Appeal Decision

Appeal Ref: 6001184

21 Kertland Street, Savile Town, Kiklees, Dewsbury WF12 9PU

Appeal Ref: 6001183

First Floor Plan As Proposed
 Scale 1:100

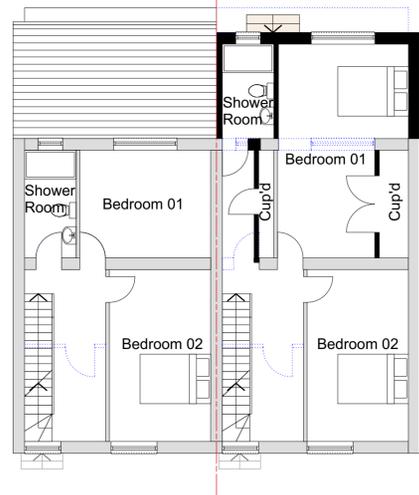
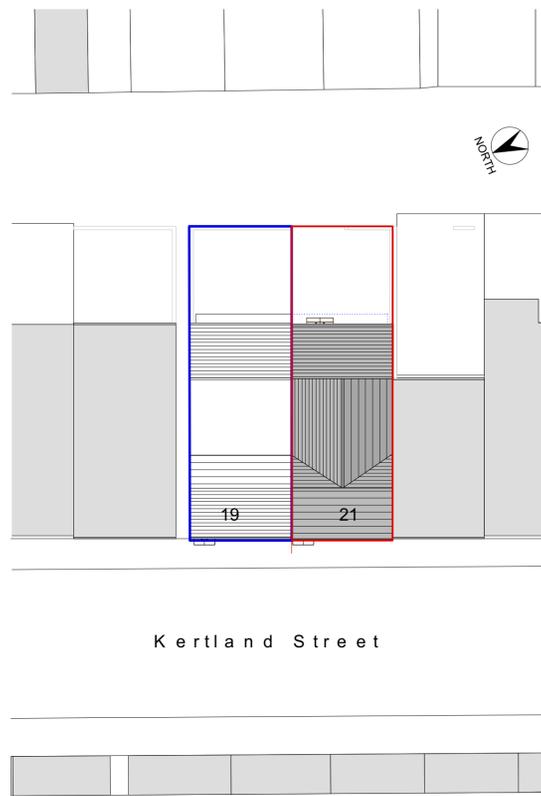
15. The submitted plans indicate that there would be no change to the ground floor but the first floor would have a larger bedroom (bedroom 01) and a re-positioned separate shower room. The second new floor would provide a large bedroom (bedroom 03) with an en-suite. I accept that the proposal would provide enlarged family accommodation and the enlarged bedrooms on either the first or second floors would provide bedroom and bathroom facilities on one floor. However, the layout would still mean that the occupant with the particular needs would still have to negotiate stairs to an upper level and use living and kitchen facilities on the ground floor.

Front Elevation As Proposed
 Scale 1:100

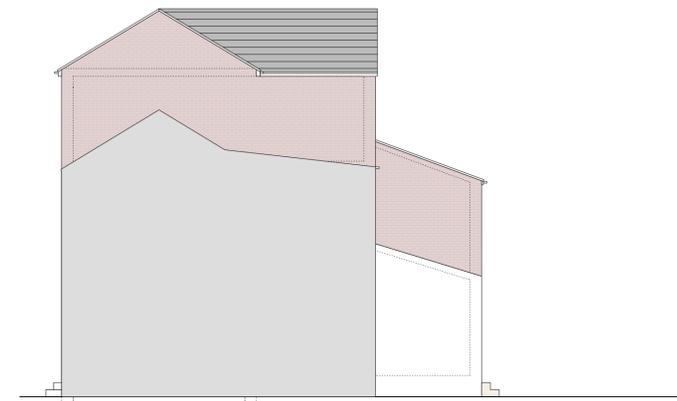
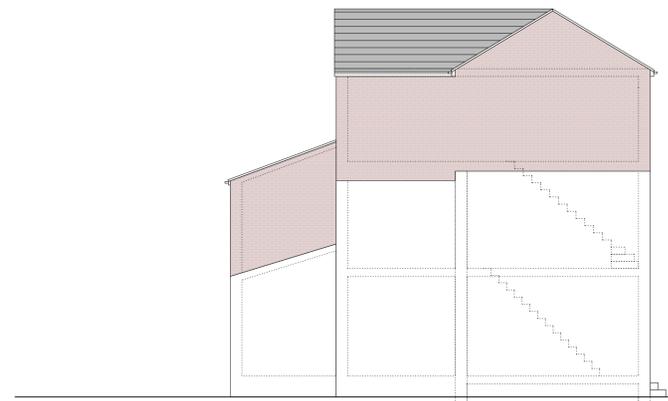
8. However, from Kertland Street, the character of the houses is that of modest two-storey houses. There is a uniformity in the terrace and a cohesiveness in the traditional design. Adding an additional storey to one or both of these properties would significantly affect the harmony created by the existing appearance of the terrace. This has already been severely affected in Grosvenor Street by the extensions there. I also note similar upward extension elsewhere in the surrounding streets. Replicating them in Kertland Street would significantly undermine the original character of the host properties, the terrace as a whole and the surrounding areas.

9. Although the plans show each of these proposals separately and there is nothing before me to illustrate them together, the effect of both scenarios is clear. I therefore find that the additional storey to these houses, both individually and collectively, would be harmful.

10. The Council has indicated that first floor extensions may be acceptable and I agree depending on the roof design. However, the proposals do not indicate how this would be achieved and so the proposal is unacceptable, in each case, in their entirety.
